I am writing to formally raise significant concerns regarding the proposed 13-storey housing development at 25–27 Boyd Street, Tweed Heads (25-27 Boyd Street, Tweed Heads Affordable Housing), as detailed in the submission documents prepared by Homes NSW and its associated consultants. After thoroughly reviewing the Traffic Impact Assessment (TIA) by Cathy Thoms and Sean Morgan (Ver04, Reference: P2559, 28 November 2024), the Social Impact Assessment (Final Report, 28 November 2024), Appendix G (cost and procurement details), the Environmental Impact Statement (EIS), the Accessibility and Arborist Reports, the Landscape and Public Domain Plan, the Design Report, the Architectural Drawings, and other relevant documentation, I have identified numerous critical issues that require immediate attention and response.

## **2. Traffic and Road Network Capacity Constraints (Reference: TIA, Ver04, P2559, 28 November 2024)**

1 S Brett Street Elevation
SCALE 1:200 @ A3

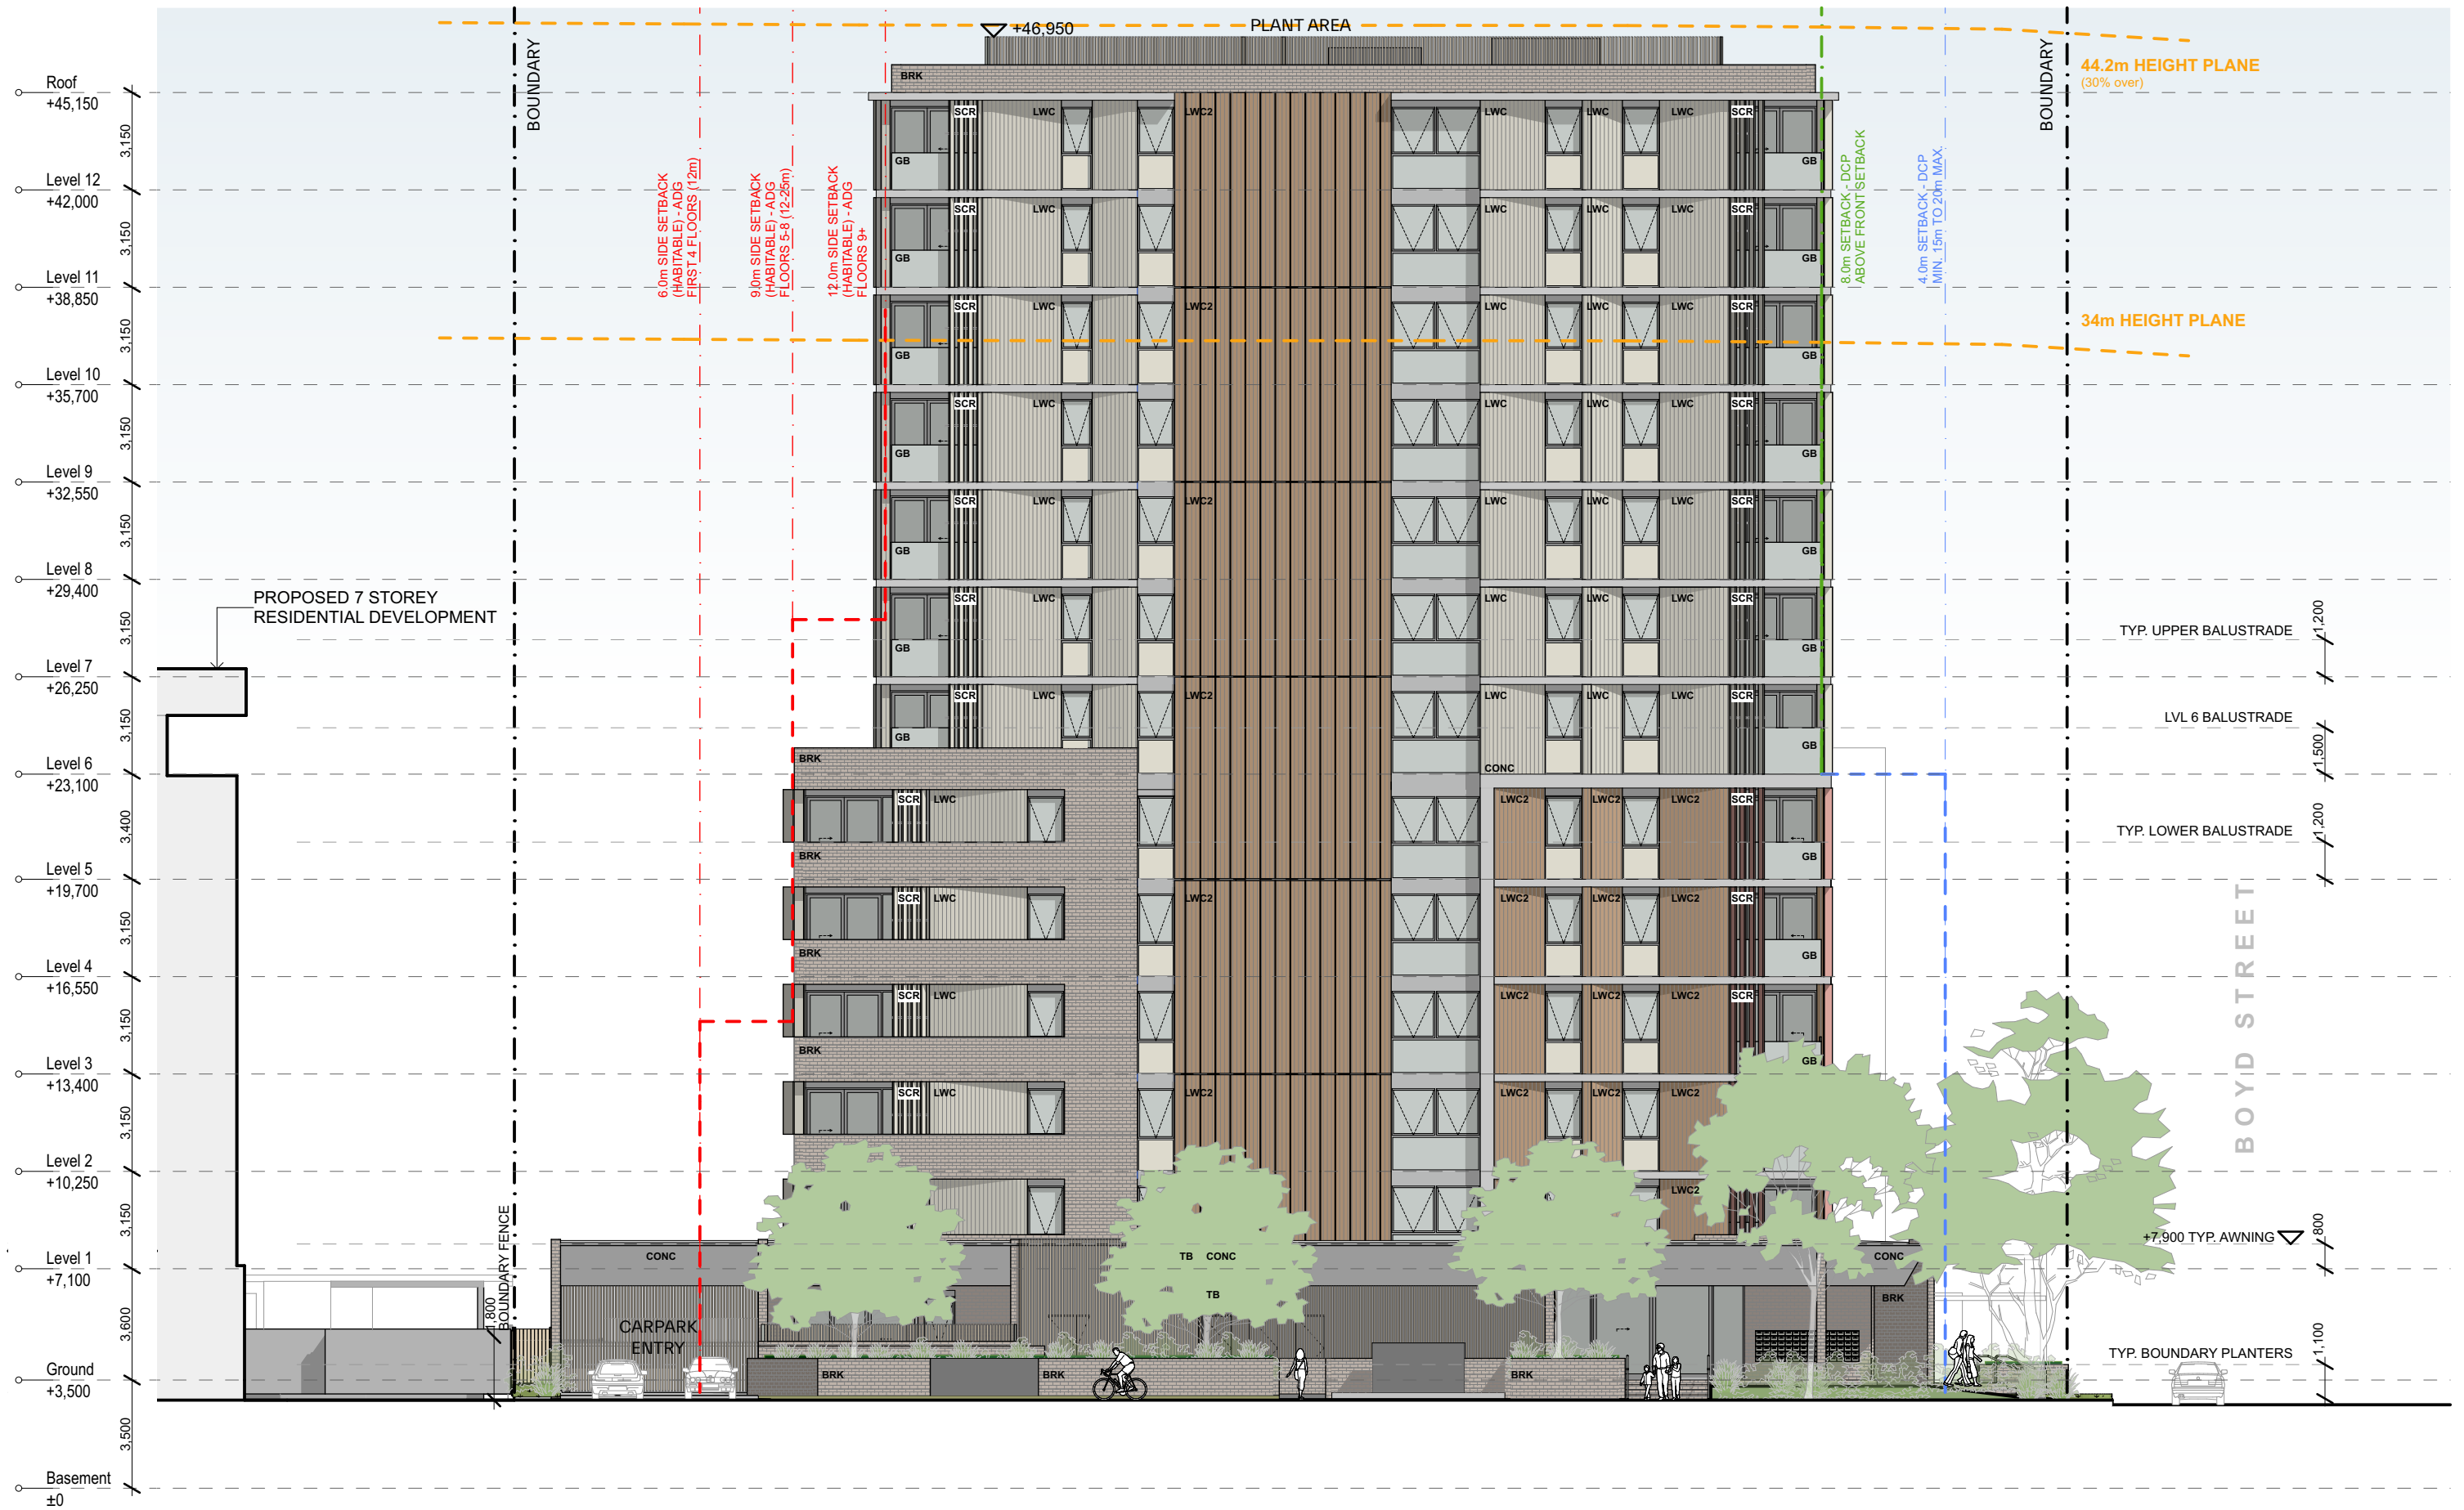
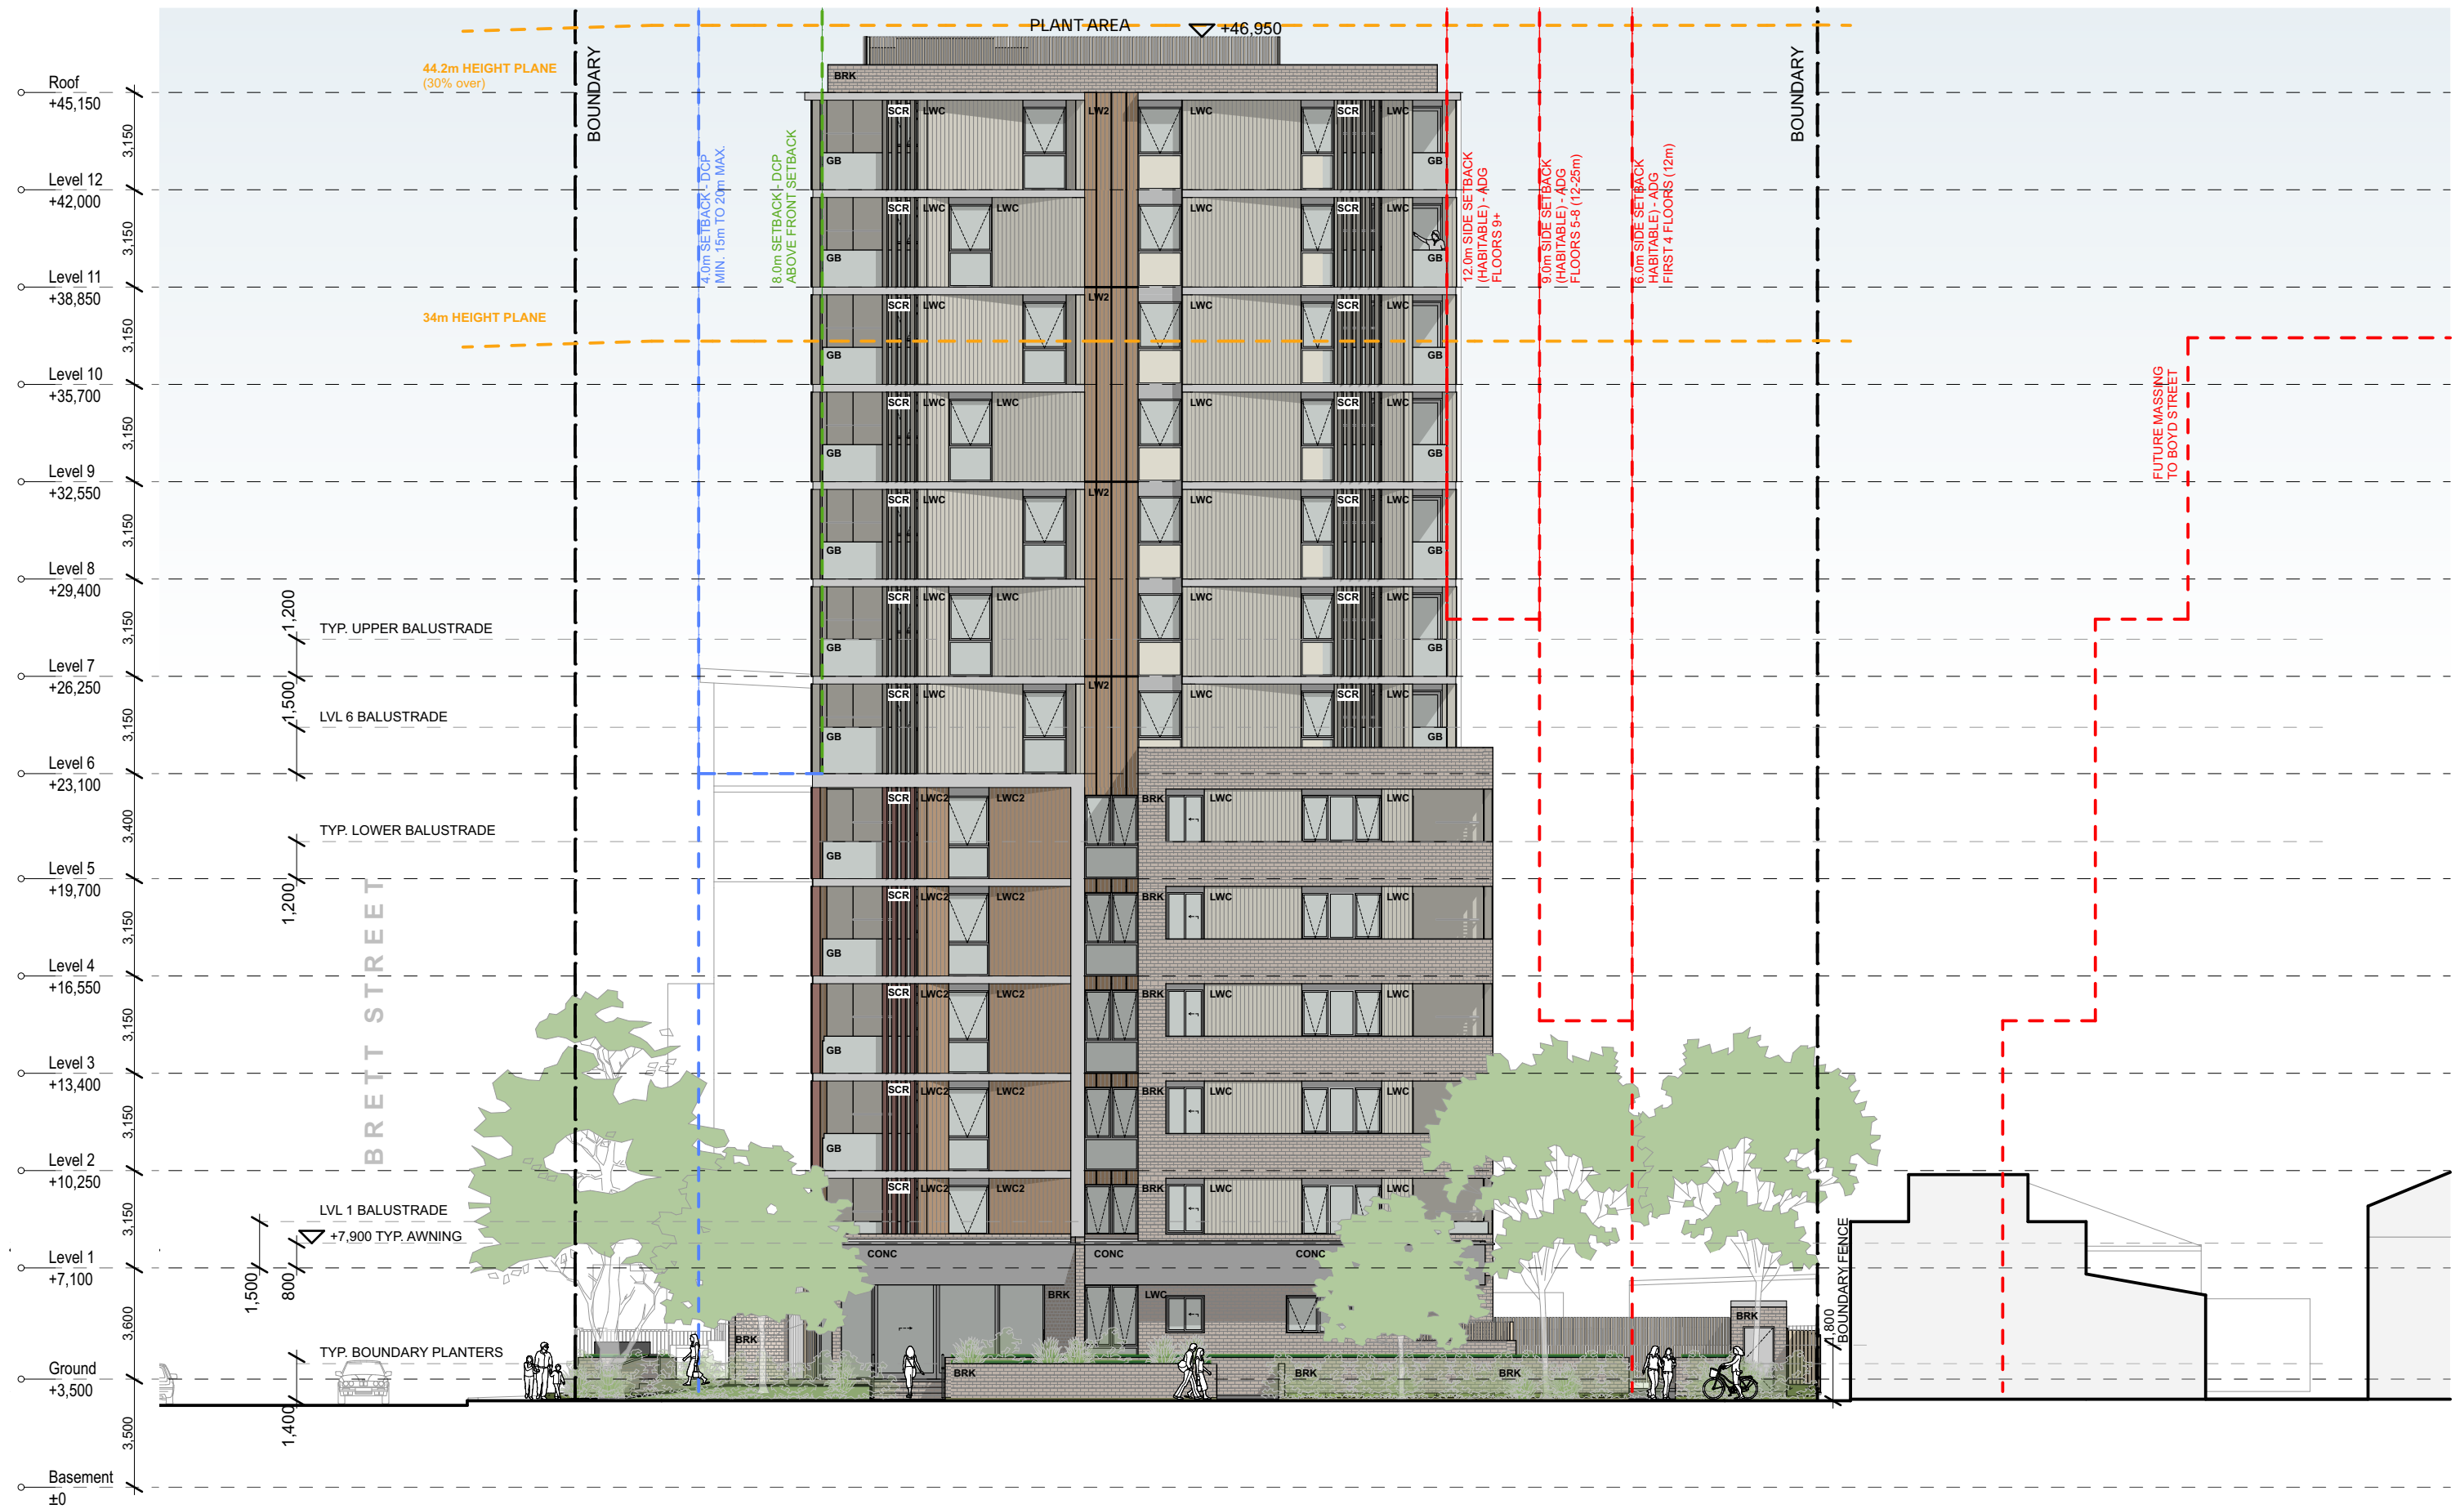
This development is grossly out of scale with its surroundings. The tallest building currently within sight of the proposed development is seven storeys. There is no precedent for a 13-storey structure in this precinct.

- Neighbourhood Character Impacts: A 13-storey tower in a low-to-medium-rise area significantly alters the character and amenity of the neighbourhood, a factor not sufficiently assessed within the submission.
